2 storey side & rear extensions, 2 storey front porch extension, single storey extension to garage, 2 rear dormer windows, new slate roof, new velux windows to front, side & rear elevations. Remodel existing garage & velux windows to be added to west side of garage roof

Spindrift Golden Acre East Preston Littlehampton

I am commenting on this application on behalf of the East Preston and Kingston Preservation Society.

Planning Drawings	DRAWING NAME. PROPOSED ROOF PLAN	
DATE October 2013	PROJECT. Spindrift Golden Acre East Preston West Sussex BN161QD	Drawing number 13
SCALE 1:100 @ A4	verify all dimensions on site for planning purposes only

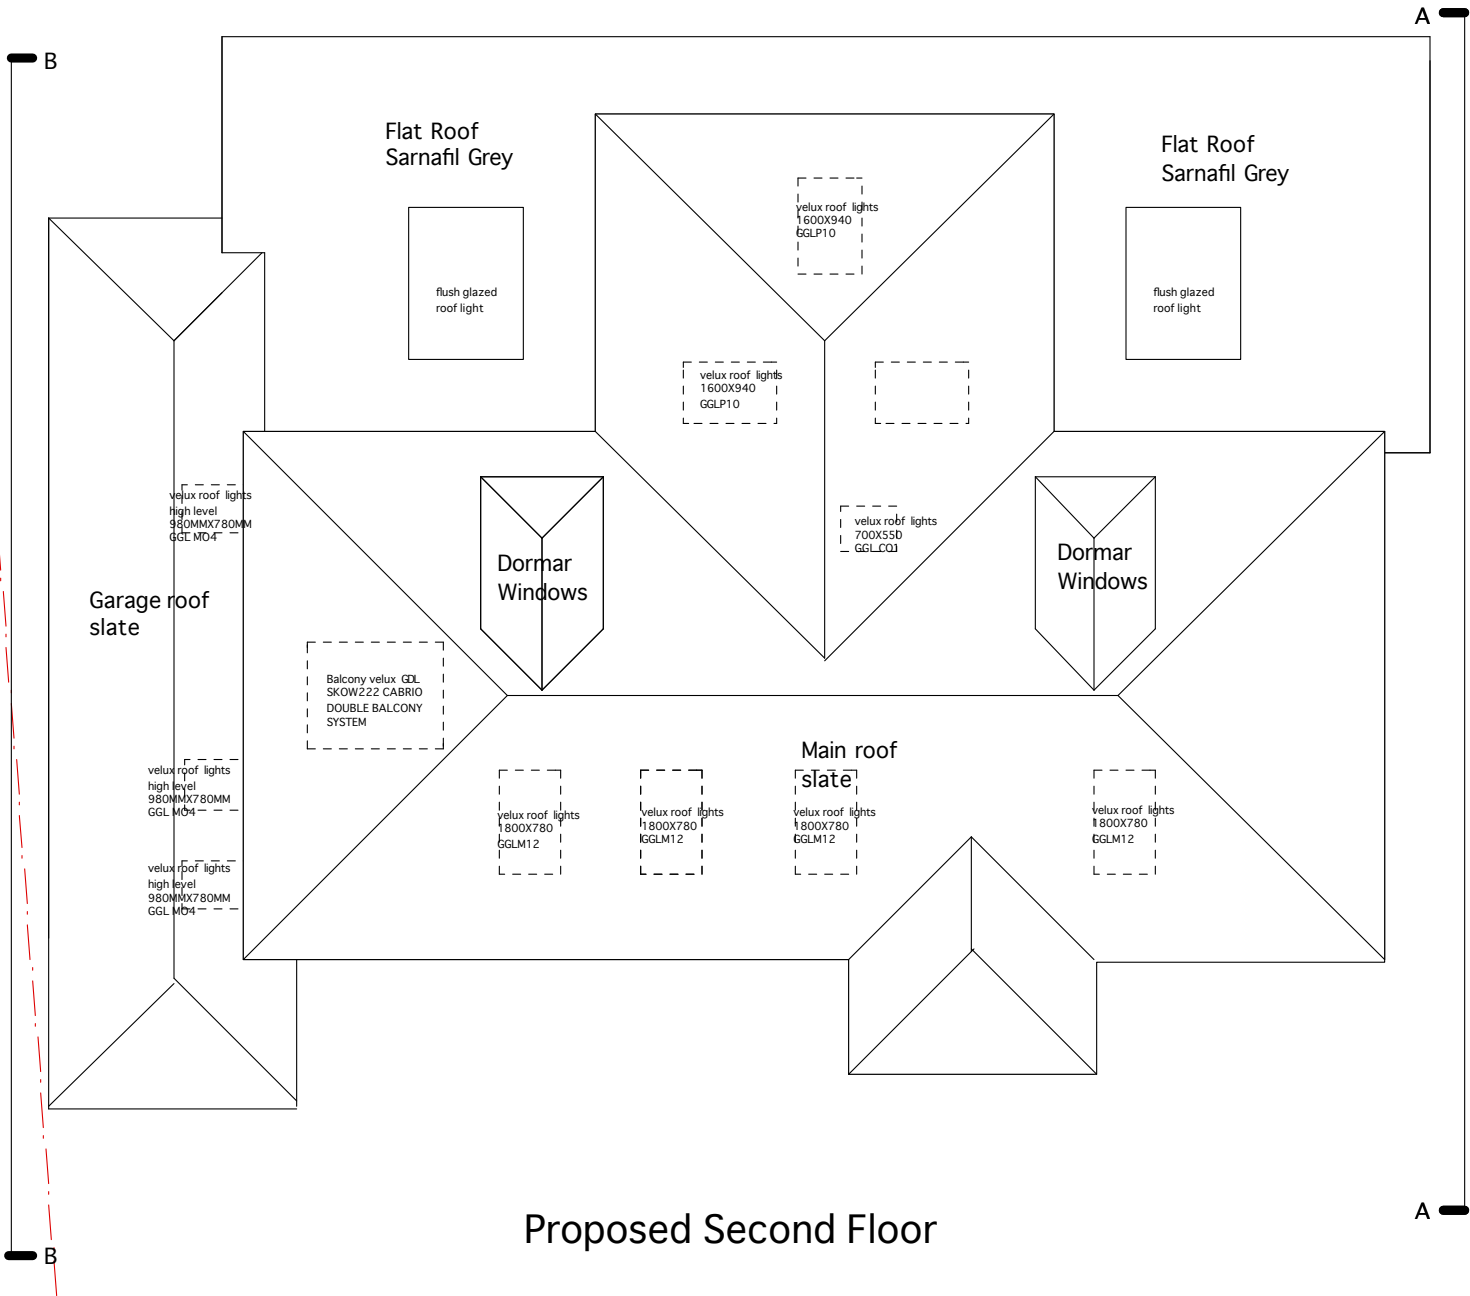
- 1. The large number of Velux windows detract from the appearance of the building. A reduction in their number would improve the appearance of the house.*
- 2. The proposed slate tiles would make an unattractive and inappropriate roofing material. Clay tiles would be more appropriate, though green glazed pantiles would be an alternative that would also match the roofing on some neighbouring houses.*
